Re Objection to Planning Application WA/68/20/OUT – Land west of Tye Lane

MOVEMENT STRATEGY PLAN

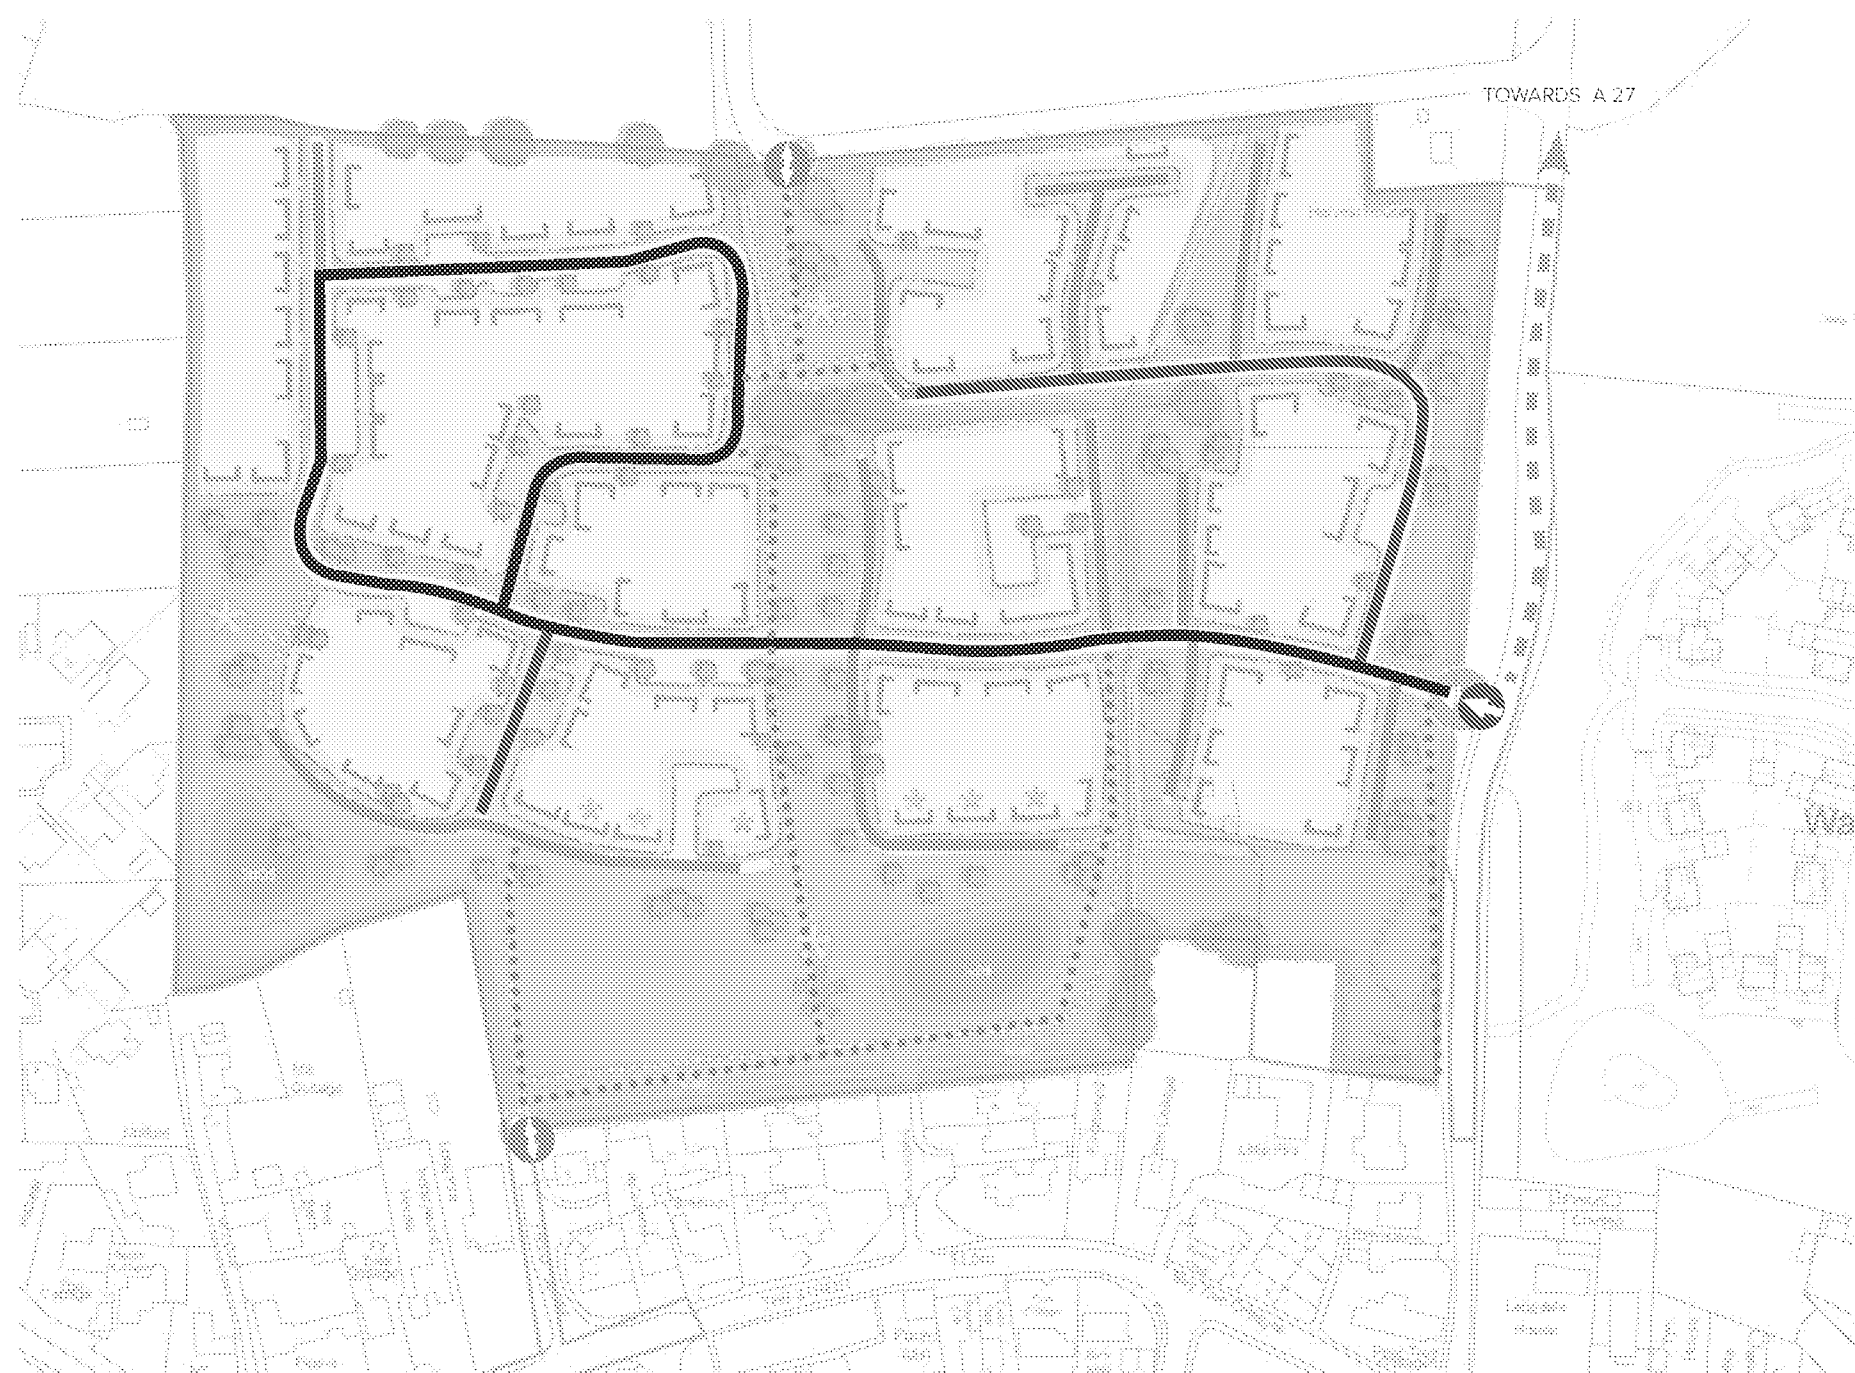
- None of the travel assessments or travel modelling take into account that the A27 bypass (the grey route) will now cross Tye Lane very close to the proposed entrance to the development and that it is likely that Tye Lane will not have access to the A27 resulting in all of the traffic from the development travelling through the village of Walberton. This not only includes the vehicles from 155 houses but also potentially all construction traffic including HGV's. According to the travel assessments the direction of 68% of this traffic is to the westbound A27. There will be no access to the A27 from Yapton Lane so 20% of the traffic that wishes to travel eastbound on the A27 will also travel west through the village up West Walberton Lane to access the A27 at the West Fontwell roundabout. Accordingly, 88% of the traffic from the development will travel westwards though West Walberton Lane, a rural country lane that is also the designated cycle route to the South Downs. This is not sustainable development! There is no designated cycle lane on this road, nor a footpath and it is already a dangerous lane to cycle or walk on. When a bus comes down the lane, generally the cars on the other side have to stop and pull over to let it pass so it is unsustainable to consider that HGV's could regularly use this route.

- The alternative would be travel through the village and along Eastergate Lane but this is an unpopular route as the entrance to the A27 West Fontwell roundabout from Fontwell Village, reached via West Walberton Lane, has priority to traffic queuing from Fontwell Avenue. It is highly likely that most of the traffic would therefore travel up West Walberton Lane.

To summarise, all traffic reports are meaningless and completely inaccurate without considering the new route of the Arundel bypass, they are also nearly four years out of date, they fail to take account of the additional 4300 dwellings proposed by the A29 modelling and do not offer the sustainable travel that they purport to and are not in accordance with the WSCC Local Transport Plan 3.
